RE: Laban Remodel – 10 Brook Bay Rd – Applicant’s Response to ESA 7/31/23 Peer Review

Wetland Resources, Inc. (WRI) received written correspondence from the City’s third-party reviewer (ESA) for the Laban Remodel (memo date: 7/31/23, authors: Maggie Bradshaw and Rachelle Tews, subject: 2301-163 SUB1 Peer Review Request; 10 Brook Bay Rd, Mercer Island, WA 98040). The following narrative re-states all ESA recommendations, as stated on page 2/3 of the review memo, as italicized, indented text. The applicant’s response immediately follows as justified, normal text.

Figure 2: Proposed Hardscape Removal

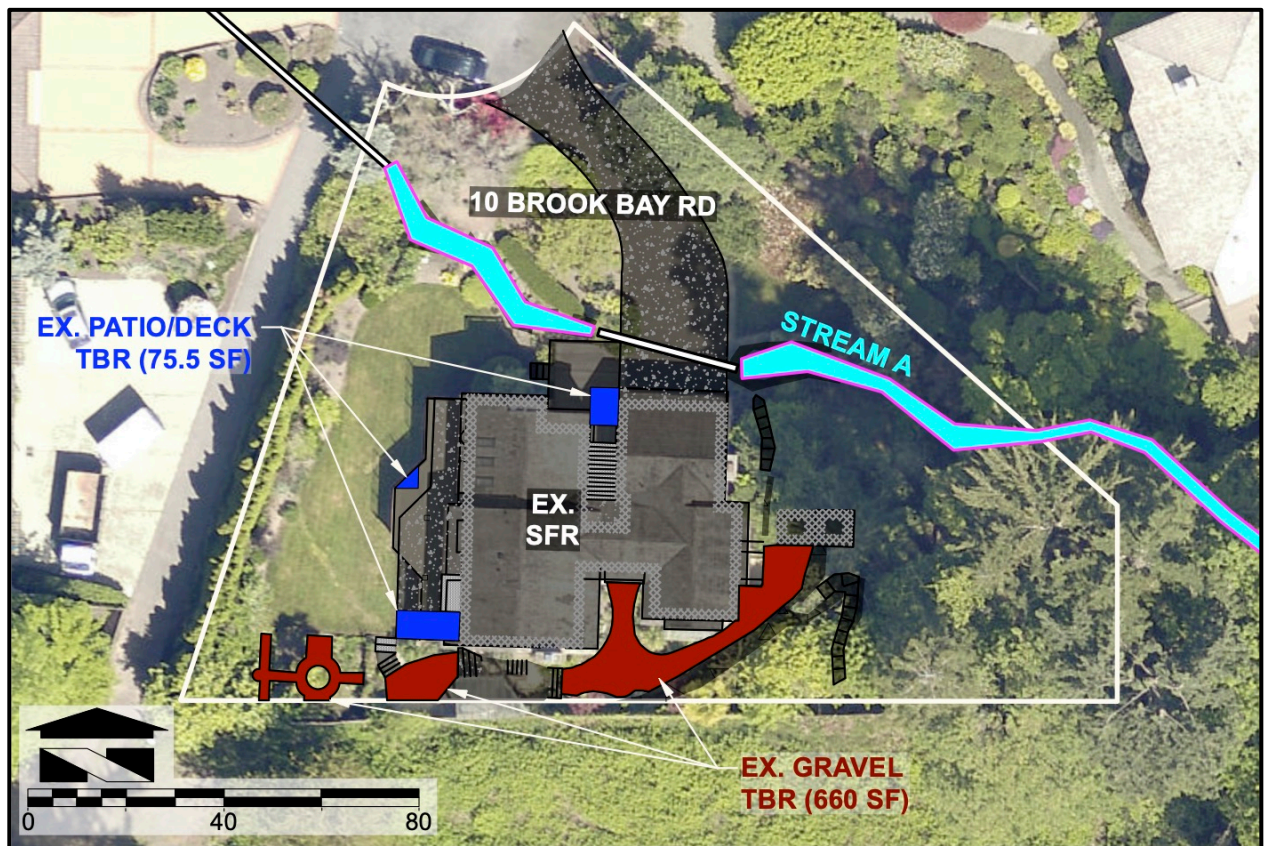
Though the project is generally consistent with the requirements of MICC 19.07.130, additional measures to protect environmental quality may be required. The CAS could provide additional information regarding the hardscape removal and provide a simple planting palette of native shrubs within the area.

-Page 2 of the revised 9/21/23 CAS provides additional information regarding the hardscape removal.
-The Mercer Island City Code states that mitigation measures for watercourse and watercourse buffer impacts “shall achieve equivalent or greater ecological function...” The proposed project achieves equivalent or greater function by reducing lot coverage and hardscape area, and is therefore in compliance with MICC 19.07.180.E.
